March 9, 2026

**RE: Flatwoods Middle School – Fire Sprinkler
Lillington, NC – Harnett County**

Plans relative to the above-named project received on March 9, 2026 have been reviewed for general compliance with the 2018 North Carolina Building Code, the National Fire Protection Association (NFPA 13) Standard for the Installation of Sprinkler Systems, 2013 edition. Per Chapter 23 of this standard, the following shall be submitted with working plans to perform a complete review.

SITE PLAN

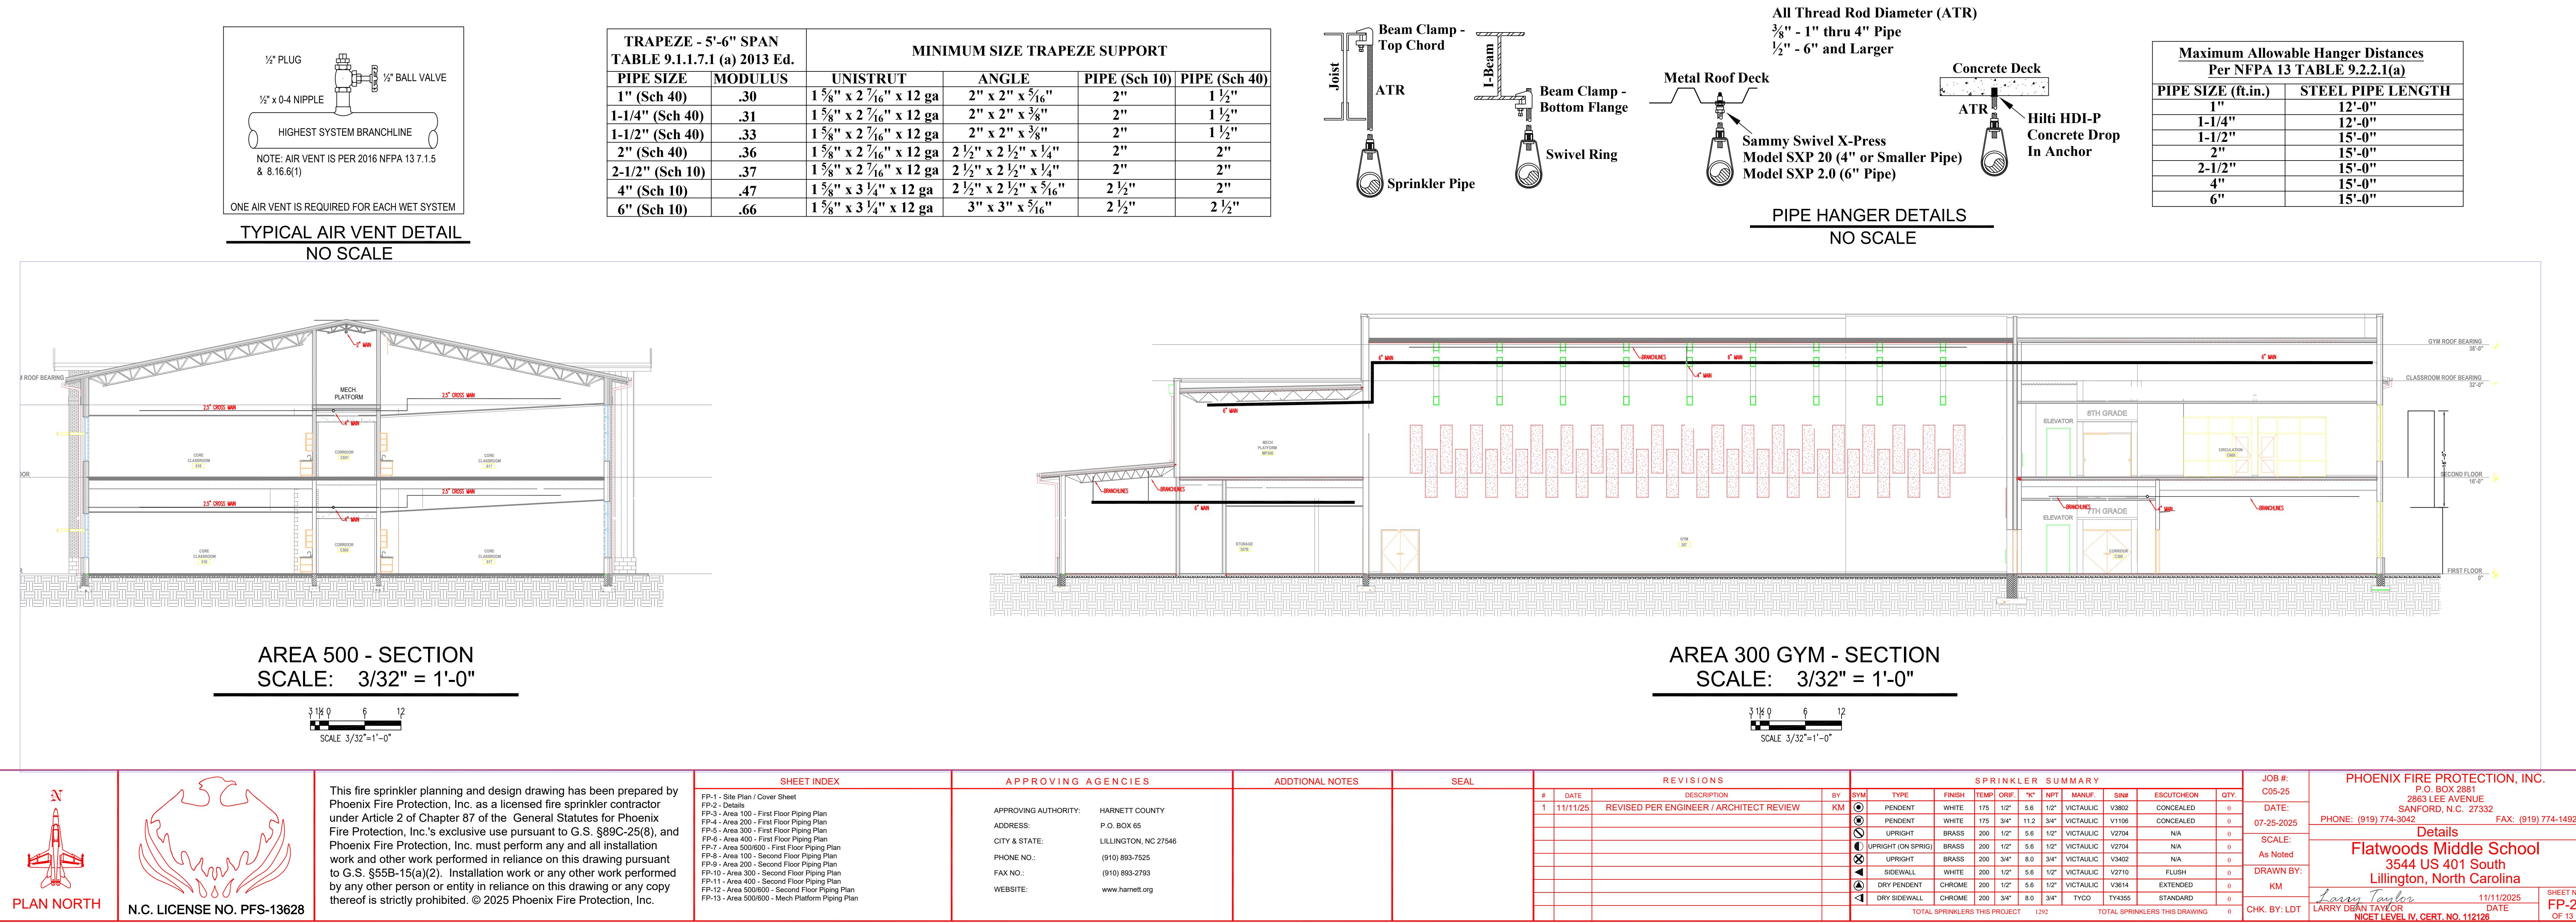
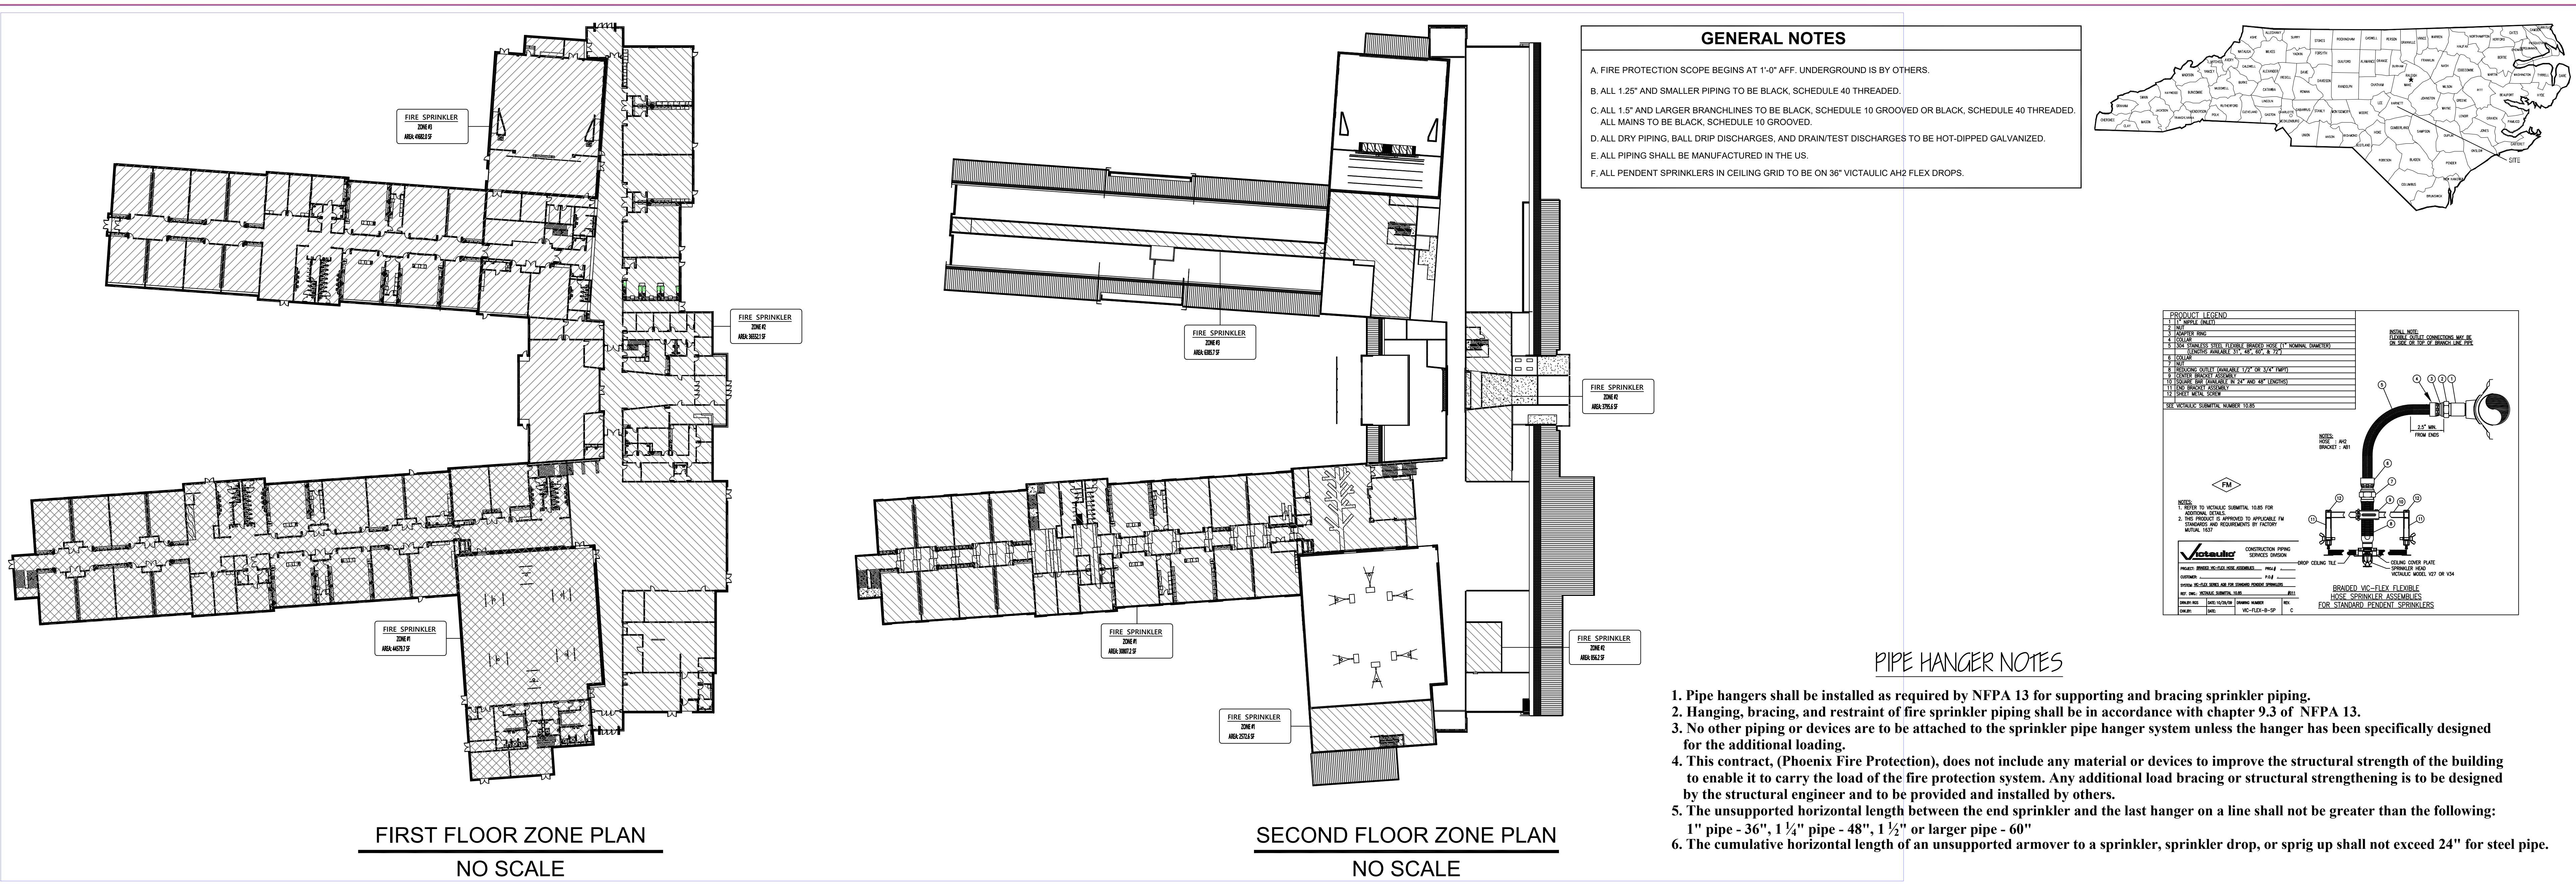
1. Comment response #10 noted, Civil/Utility to provide when available. Provide cut sheets to confirm types of valves, valve indicators, regulators, meters, and valve pits, and the depth that the top of the pipe is laid below grade per NFPA 13, Chapter 23, section 23.1.3 #28.
2. Comment response #11 noted, Civil/Utility to provide when available. Provide provisions for flushing the underground private main per NFPA 13, Chapter 23, section 23.1.3 #29.
3. Comment response #12 noted, Civil/Utility to provide when available. Provide cut sheets on backflow preventer per NFPA 13, Chapter 23, section 23.1.3 #41.
4. Comment response #14 noted, Civil/Utility to provide when available. Provide cut sheets to confirm size, location and piping arrangement of fire department connection (FDC) per NFPA 13, Chapter 23, section 23.1.3 #44.
